Our Ref: EP/81/26/NMA

**Section 96A of the Town & Country Planning Act 1990 (as amended)
Town and Country Planning (Development Management Procedure) (England) Order 2015
(as amended) - Article 10**

Non material amendment following the grant of EP/113/25/HH relating to changes to elevations including amendments to doors, roof, cladding and brickwork.

57 Manor Road East Preston BN16 1PY

1:100 East elevation as proposed

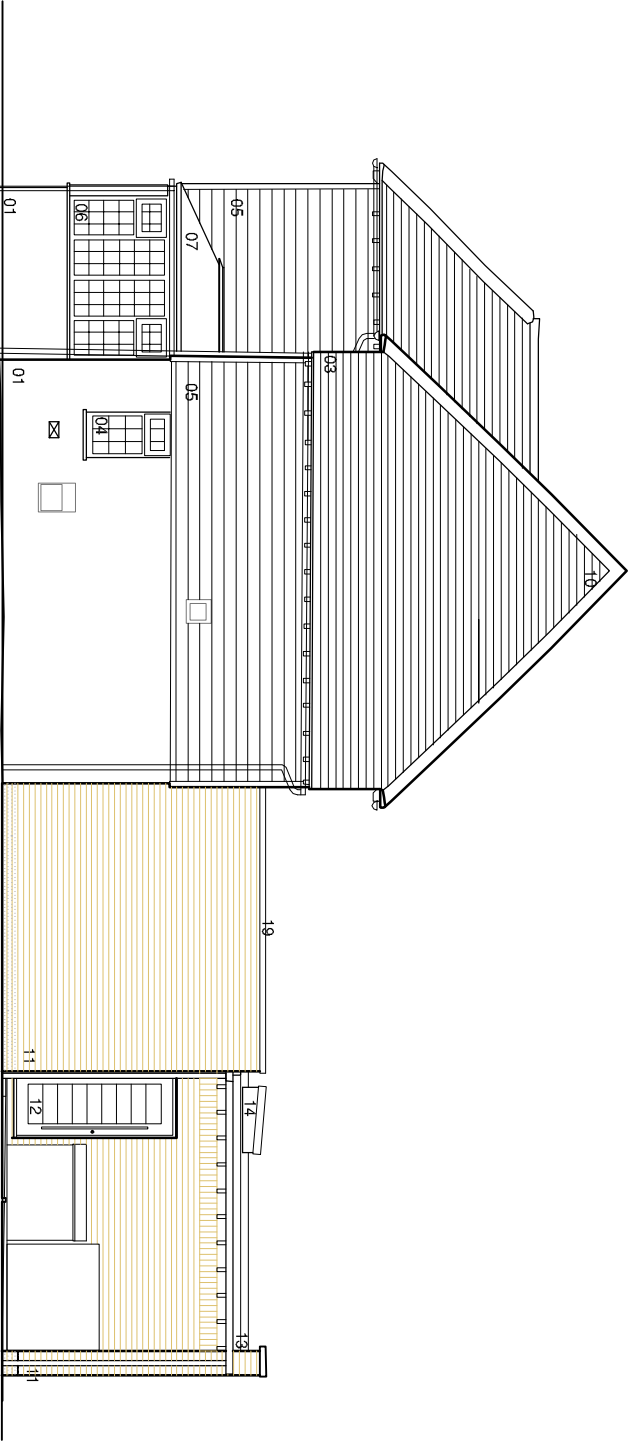
This proposal seeks the increase in width of the garage door by 0.5m, amend the type of cladding on the west elevation to Siberian Larch, amend the front and rear doors to be solid aluminium, replace the proposed cantilevered roof with a parapet, adding a zinc roof edge to the west elevation and to amend the proposed fair face brickwork to be painted brick (to match the existing dwelling).

The amendments to material treatment are not considered to have an adverse impact on visual amenity and would be sympathetic to both the existing dwelling and broader locality. The addition of the parapet would be a slight change and would be no greater in height than the existing parapet on the north elevation.

From the information submitted I am able to take the alterations as a minor amendment to EP/113/25/HH. The approved plans are Proposed Floor Plans SK 07A, Proposed Elevations SK 09A and Proposed Site Plan SK 11A to replace the previously approved Proposed Floor Plans SK 07, Proposed Elevations SK 09 and Proposed Site Plan SK 11.
